Historic England

**APPLICATION BY MORECAMBE OFFSHORE WIND LTD FOR AN ORDER
GRANTING DEVELOPMENT CONSENT FOR THE MORECAMBE OFFSHORE WIND
FARM GENERATION ASSETS PROJECT**

APPLICATION REF: EN010121

**WRITTEN REPRESENTATION OF THE HISTORIC BUILDINGS AND MONUMENTS
COMMISSION FOR ENGLAND (HISTORIC ENGLAND)**

Figure 8: Distribution of Archaeological Anomalies

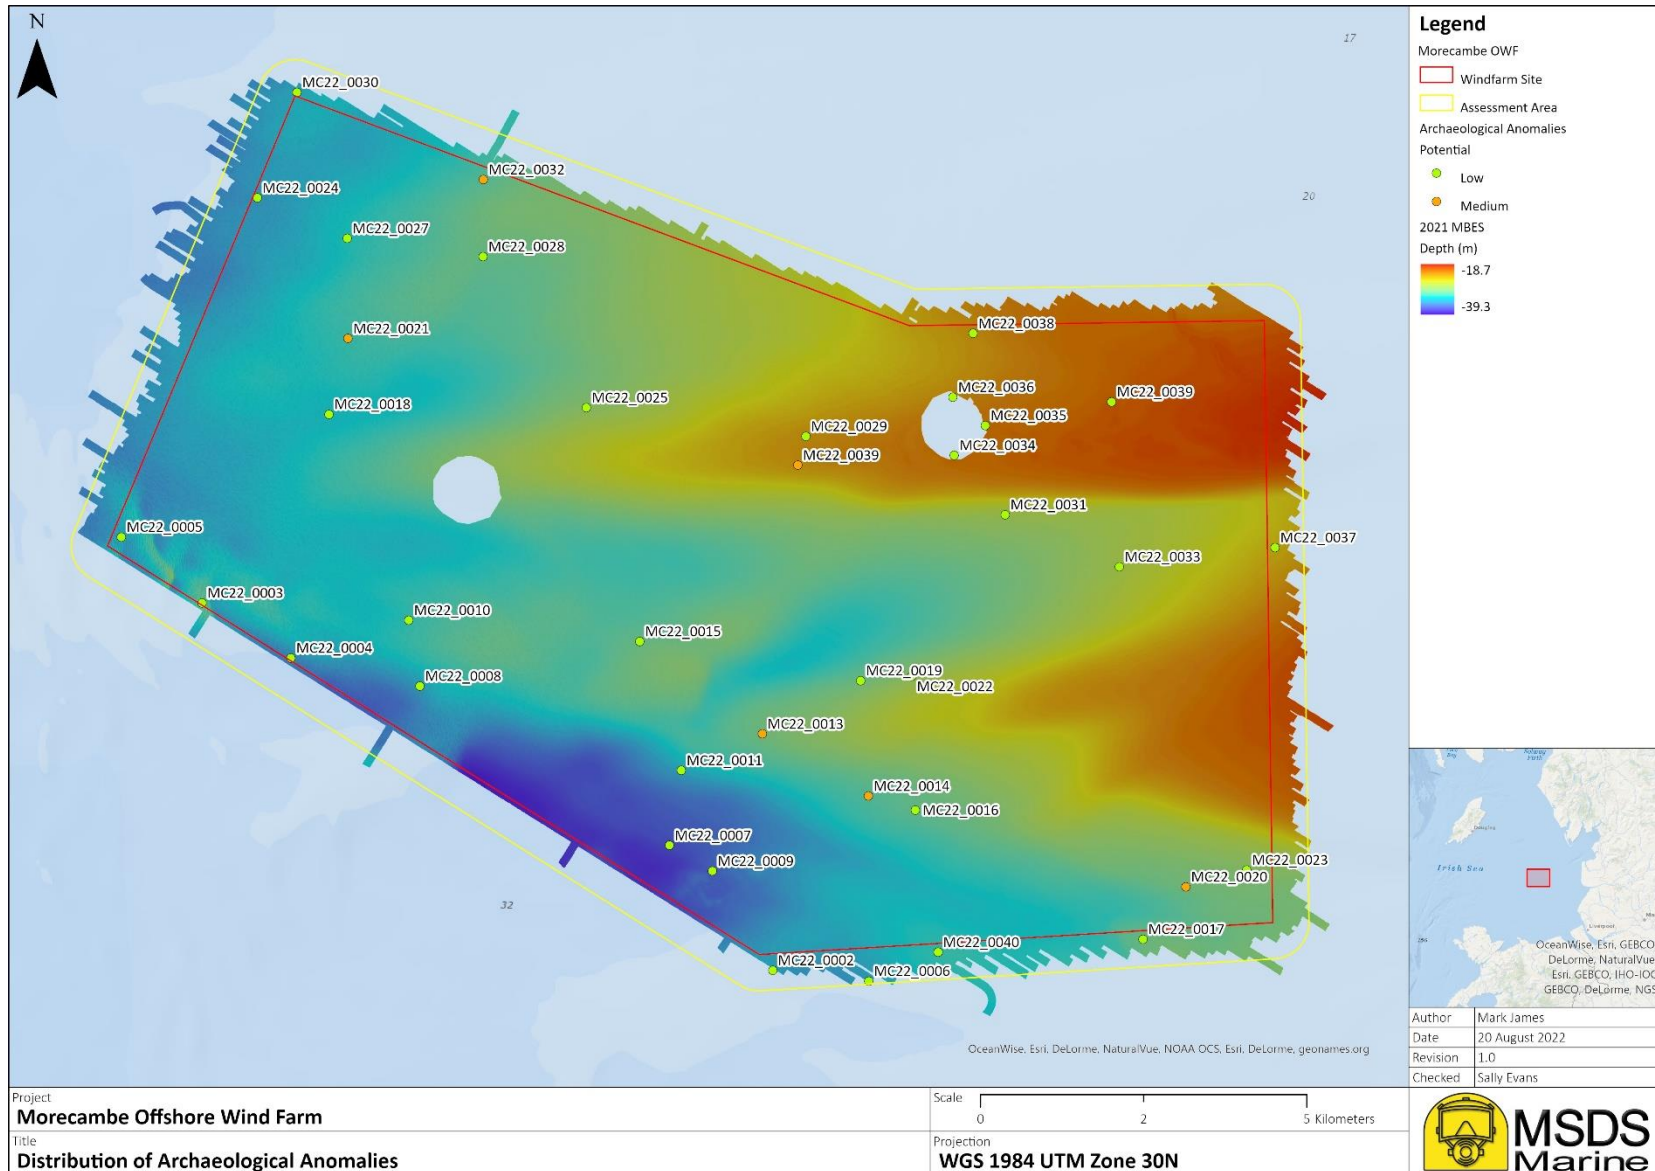
- 5.5 Section 6 states that a total of 38 anomalies of potential archaeological interest were identified within the wider archaeology study area (as illustrated in Figure 8) with 6 considered to be of "medium potential".

Figure 18: Magnetic Anomaly MC22_MAG_0254

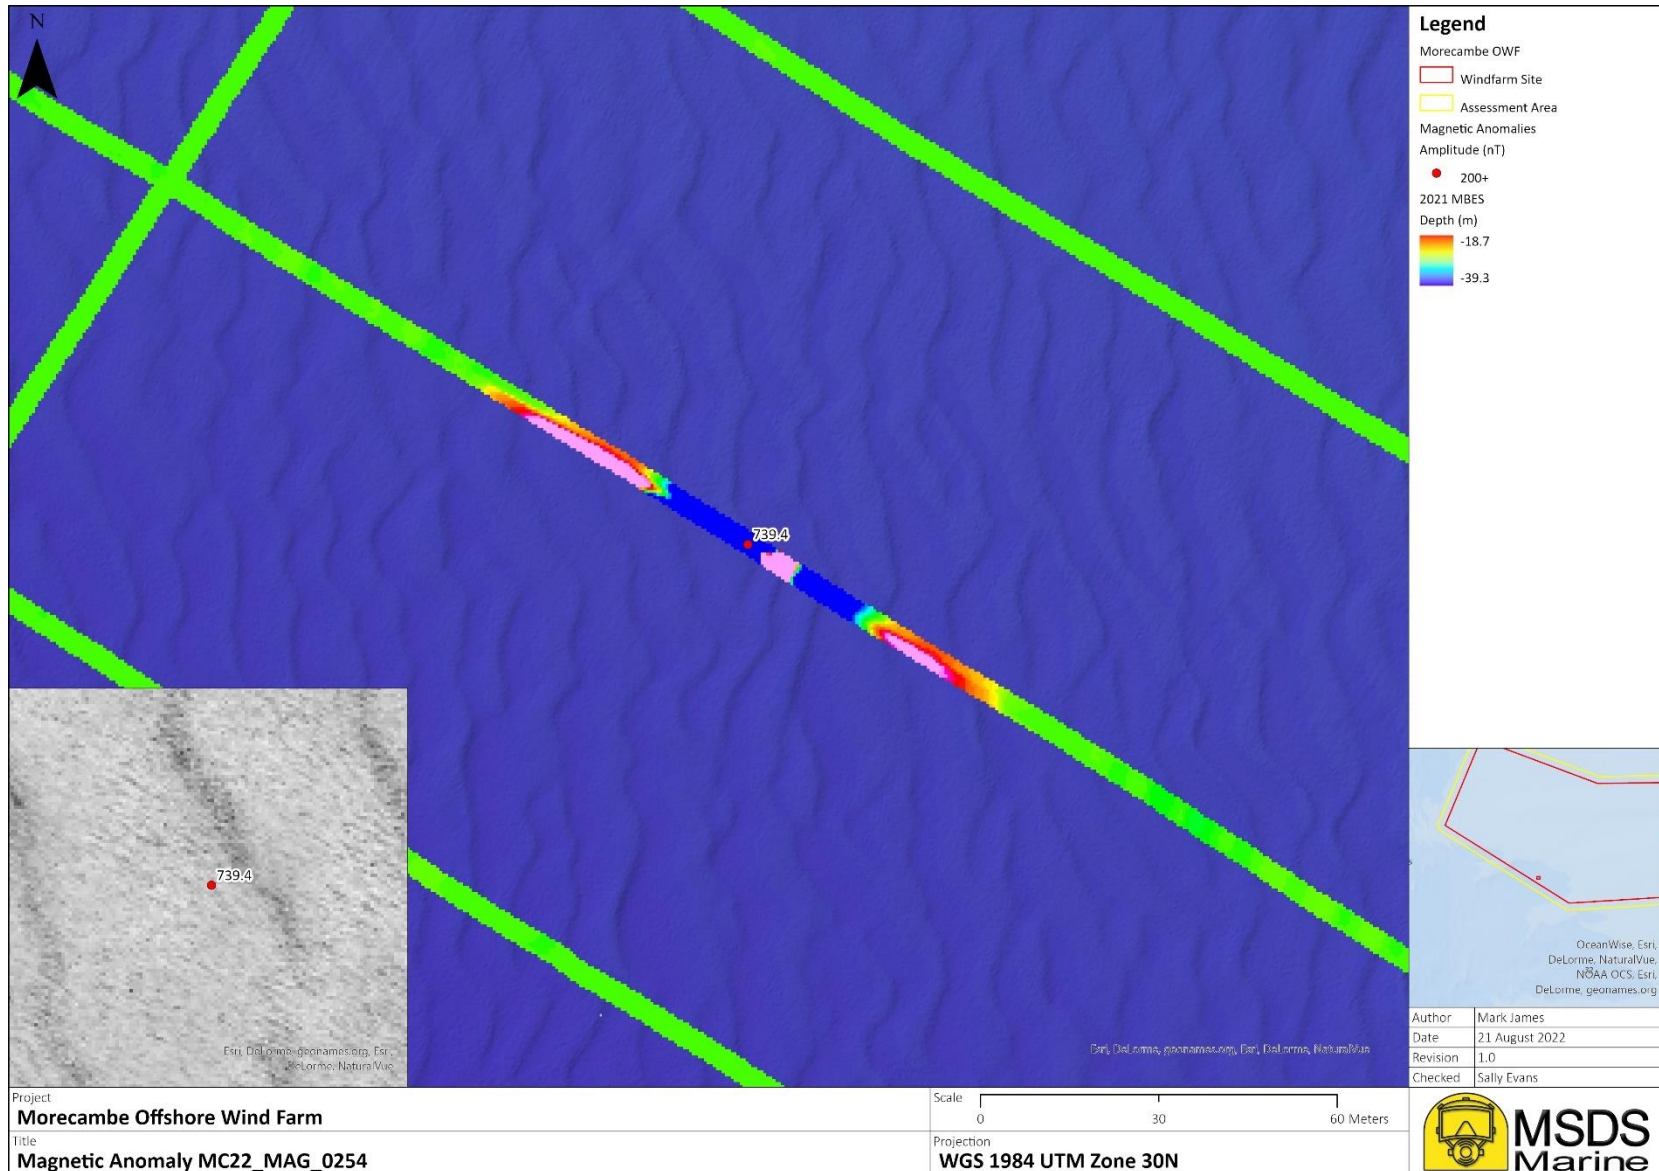
- 5.6 In the exercise to cross-reference between geophysical data only one magnetic anomaly correlated directly with an anomaly identified as of archaeological potential. However, it was acknowledged this was likely to be due to magnetometer data line spacing (as illustrated in Figure 18). The identification, at this stage of other potential anomalies, as well as UKHO and NHRE records is relevant, as subsequent high-resolution survey to inform any foundation positioning and dredging requirements will help to refine the available information. We also remain aware that other anomalies of possible archaeological interest might presently be concealed within mobile sedimentary bedforms. The attention given to palaeolandscapes in Section 10 was useful, in particular the ongoing research regarding the Holocene transgression and the corresponding debate about geoarchaeological potential, as expanded upon in Section 10.7 although the consensus seems to be that understanding the timing of Holocene transgression continues to be a key research question.
